Client: Persimmon Homes Thames Valley
Project Title: 19163- Sites A2 & B6 Littlehampton, West Sussex
Rev: - 1st Issue
Date – 14th May 2020

**Drainage Consultee Response for Residential Development at Hampton Park,
Parcels A2 & B6, Toddington Road, Littlehampton. Ref LU/90/20/doc**

Drawn	CS
Checked	TB
Drawing	
19163 - 301B

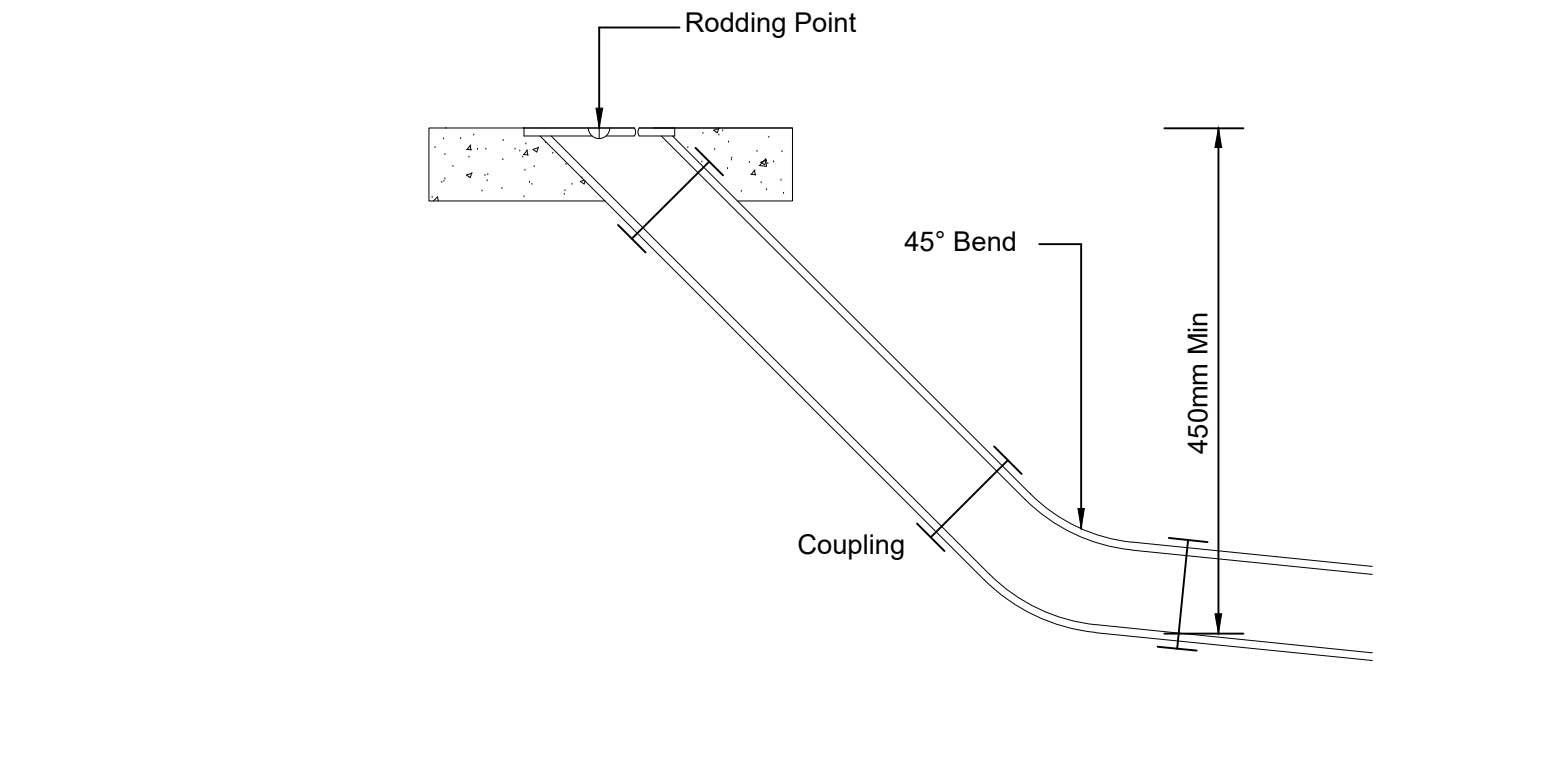
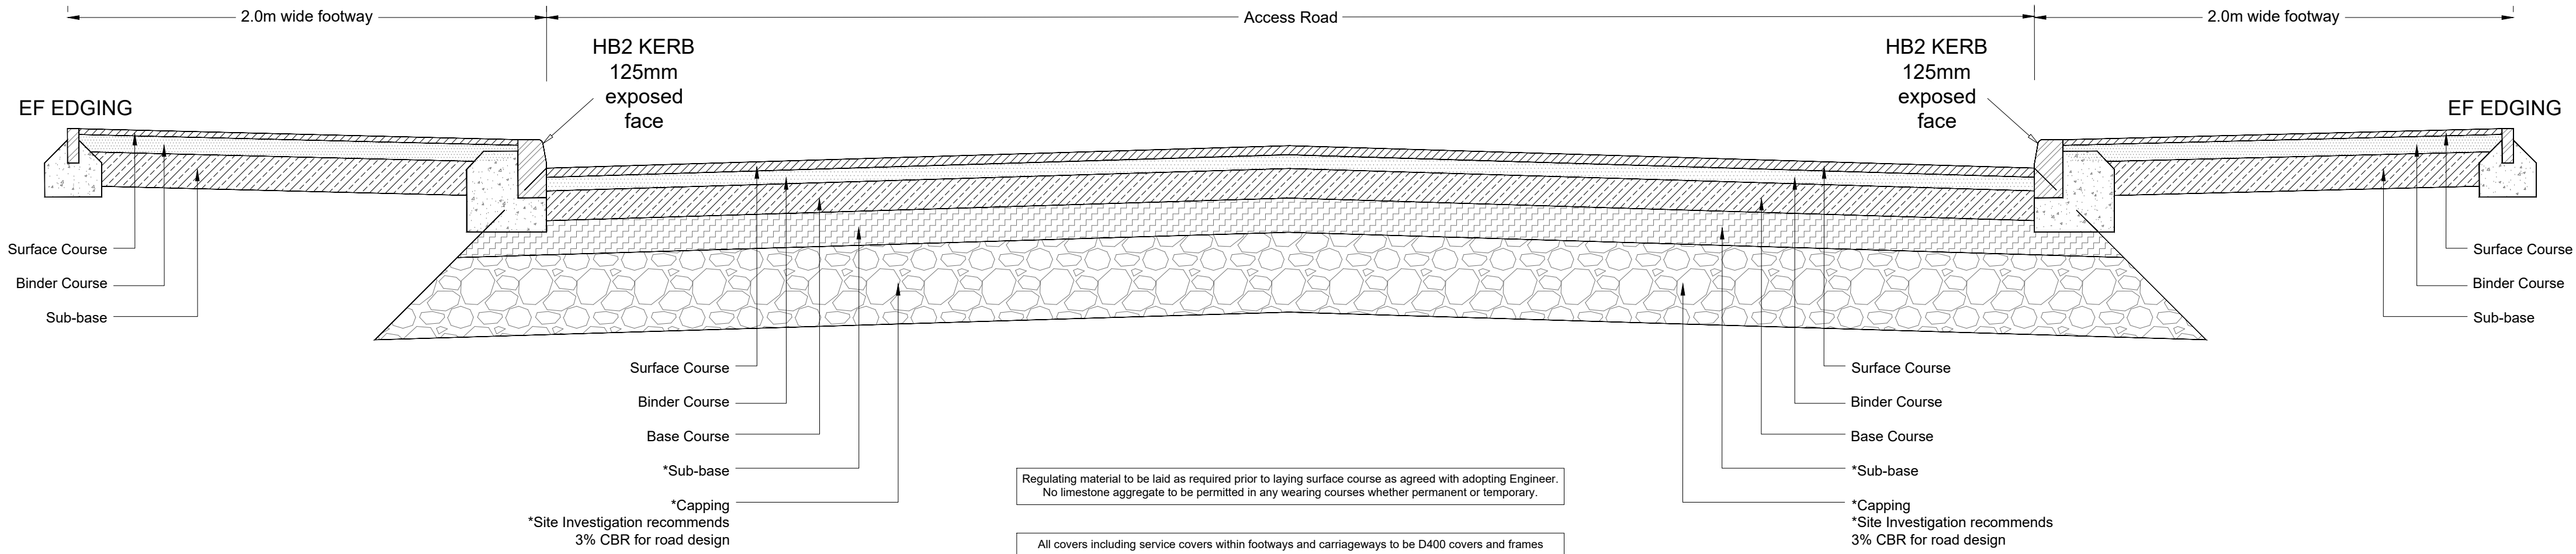
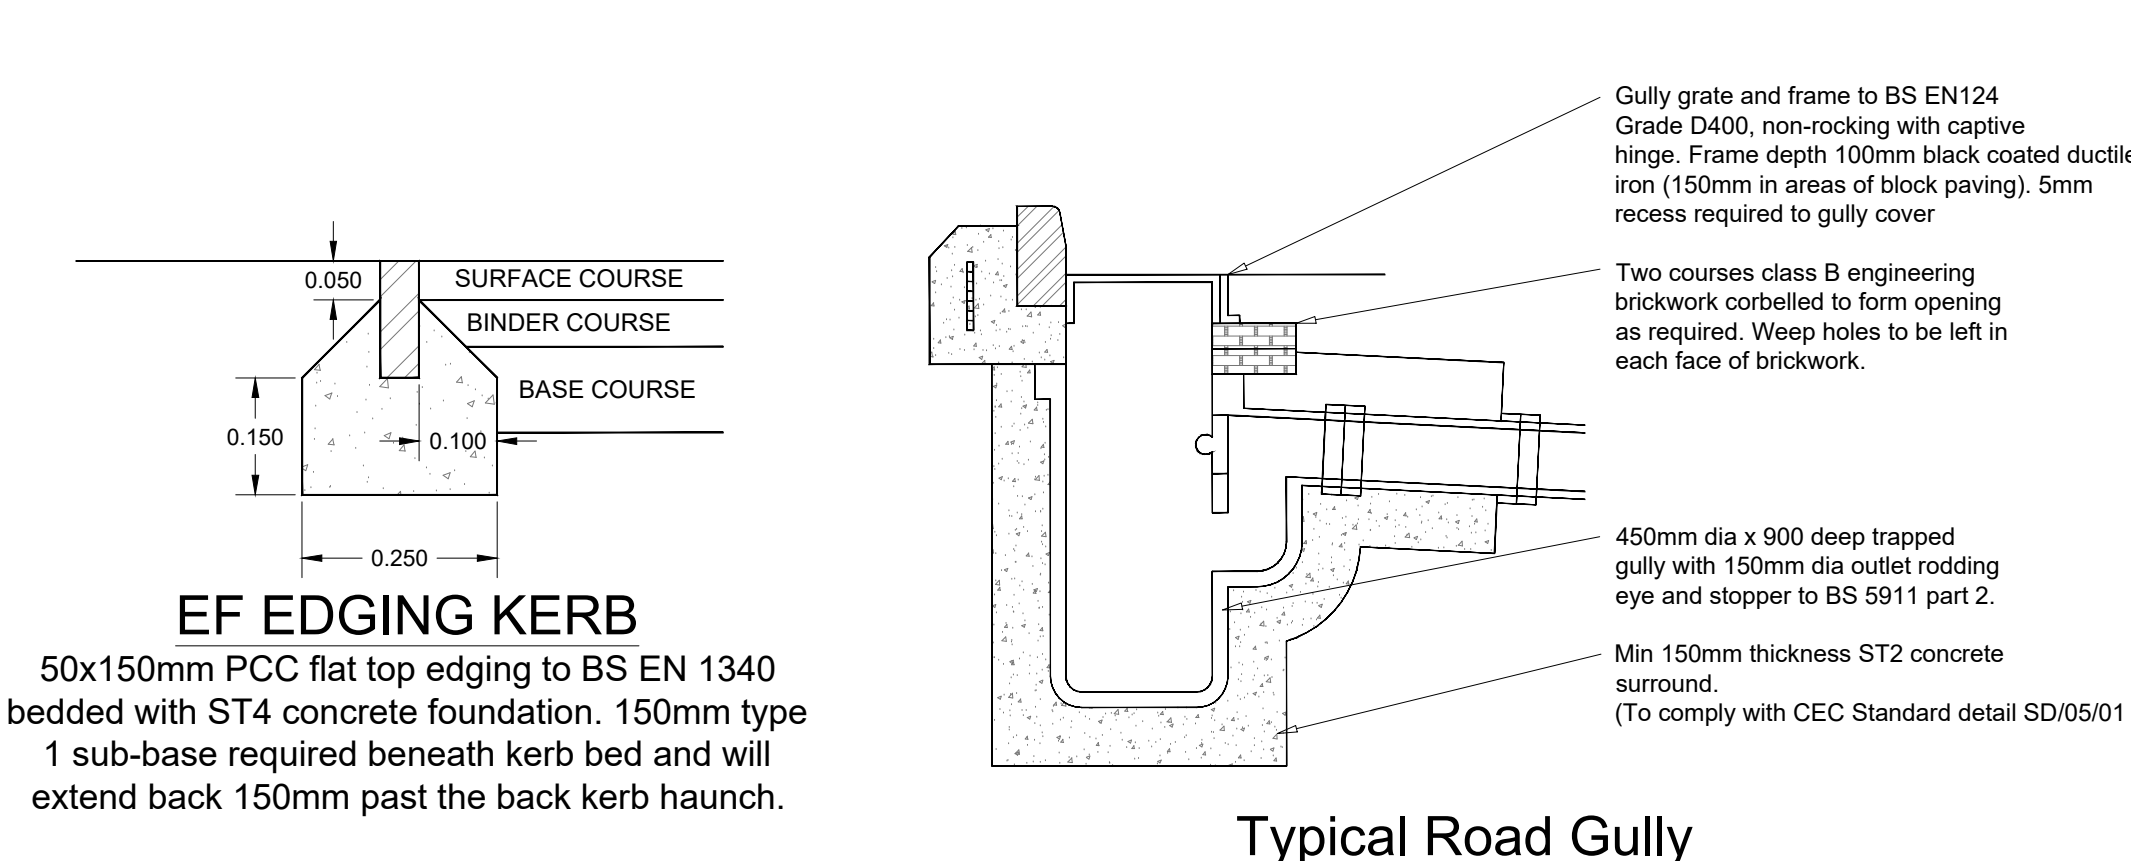
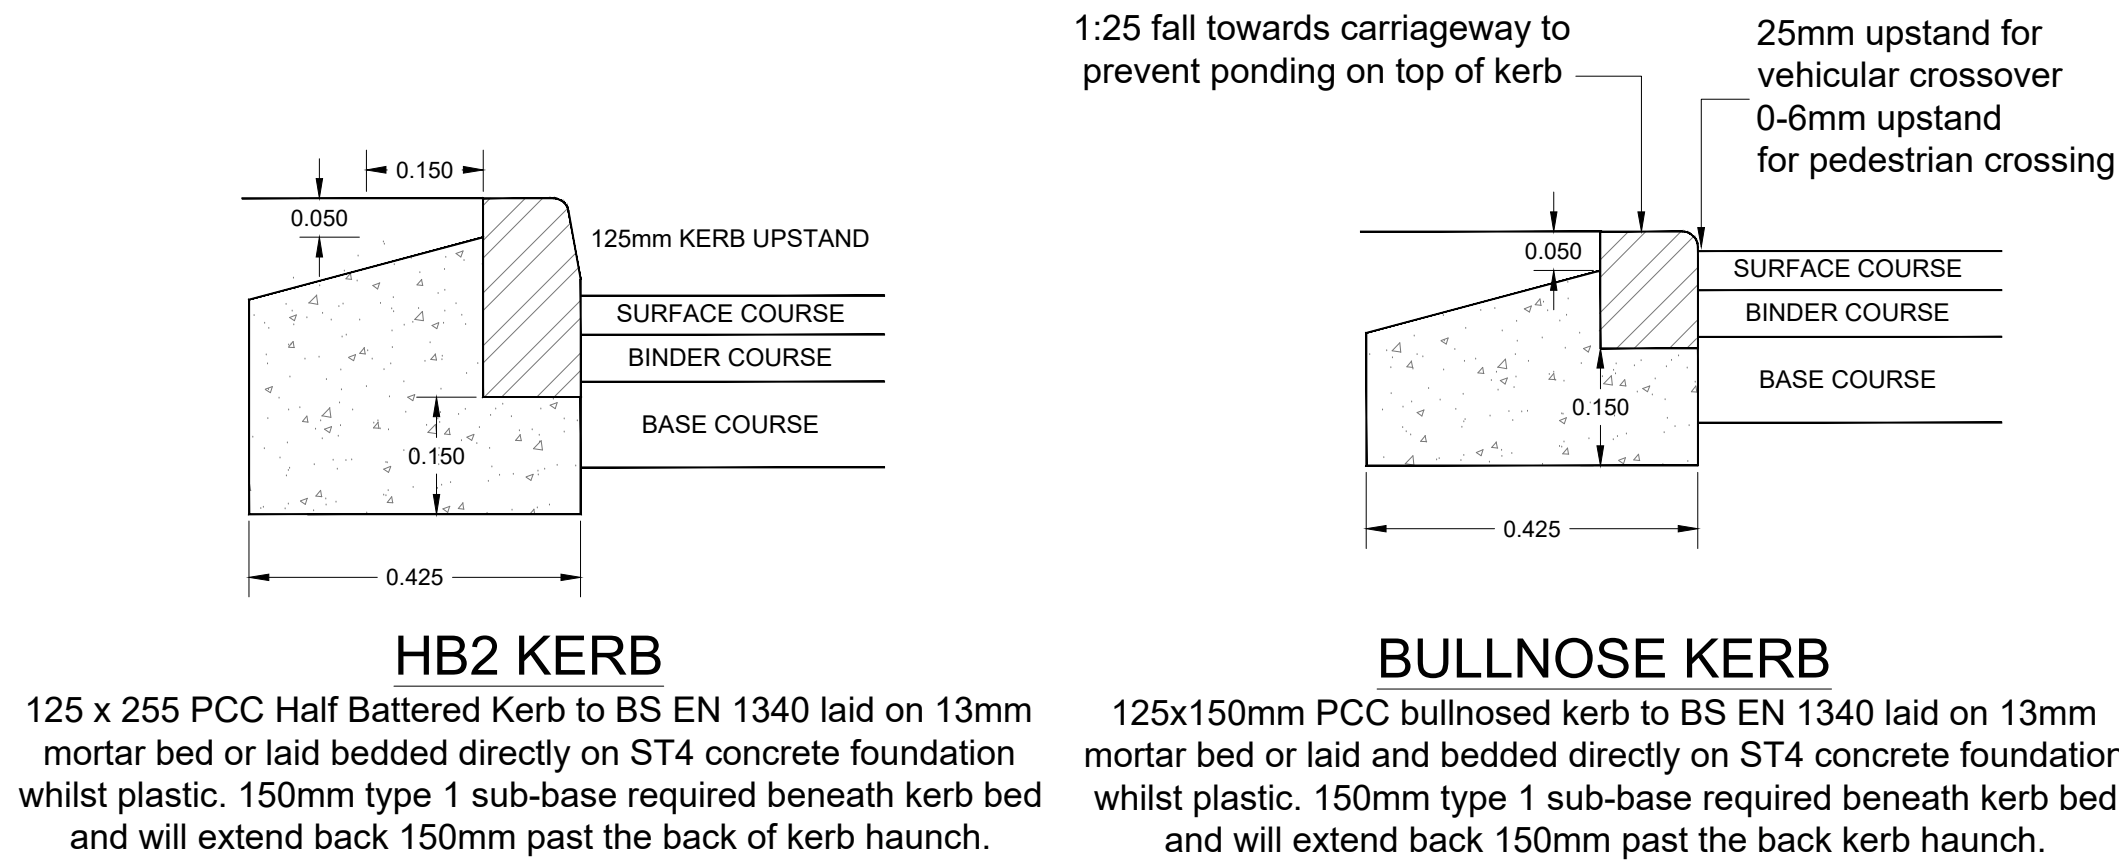
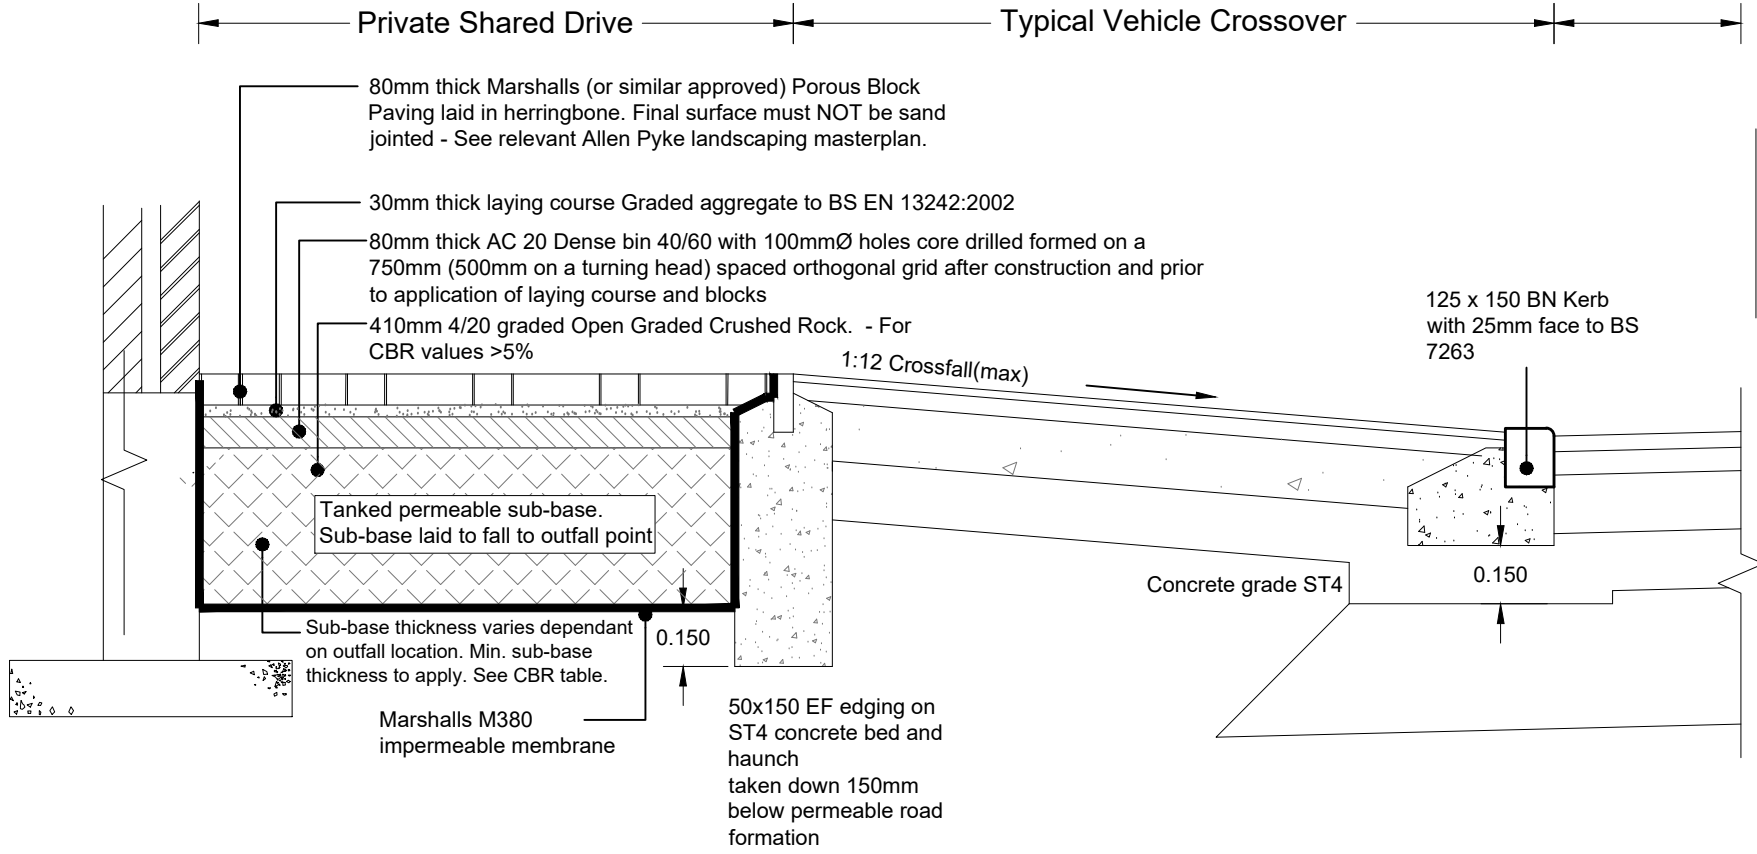
6. *Provide fully detailed construction drawings to include manholes including catchpits & hydrobrake chambers, gullies, channel drains, permeable paving and outlet sumps/diffuser unit, storage tanks, rodding eyes, pipe bedding, etc. Please refer to drawing no's 19163/301 REV B,311,323 REV A,326 REV A,GEOlight 750mm – 500mm Datasheet,& Online Bridged Attenuation Tank-Standard Detail.*

20. *Rather than running pipes under the permeable paving, can they be connected into the paving via diffuser units? The tanked permeable construction has been provided to provide a degree of treatment to the surface water runoff from communal carpark areas. The perception is these areas could be at a marginally higher risk of pollution associated with oil leaks etc. The construction of these has been kept relatively shallow. Outlet sumps have been specified at low points in the tanked car park and their purpose is to*

facilitate maintenance and if there are any issues with the operation of the car park in terms of drainage they will be apparent at these points. We have been questioned on the previous schemes on how distributors such as permovoid etc can be maintained which is not practically possible.
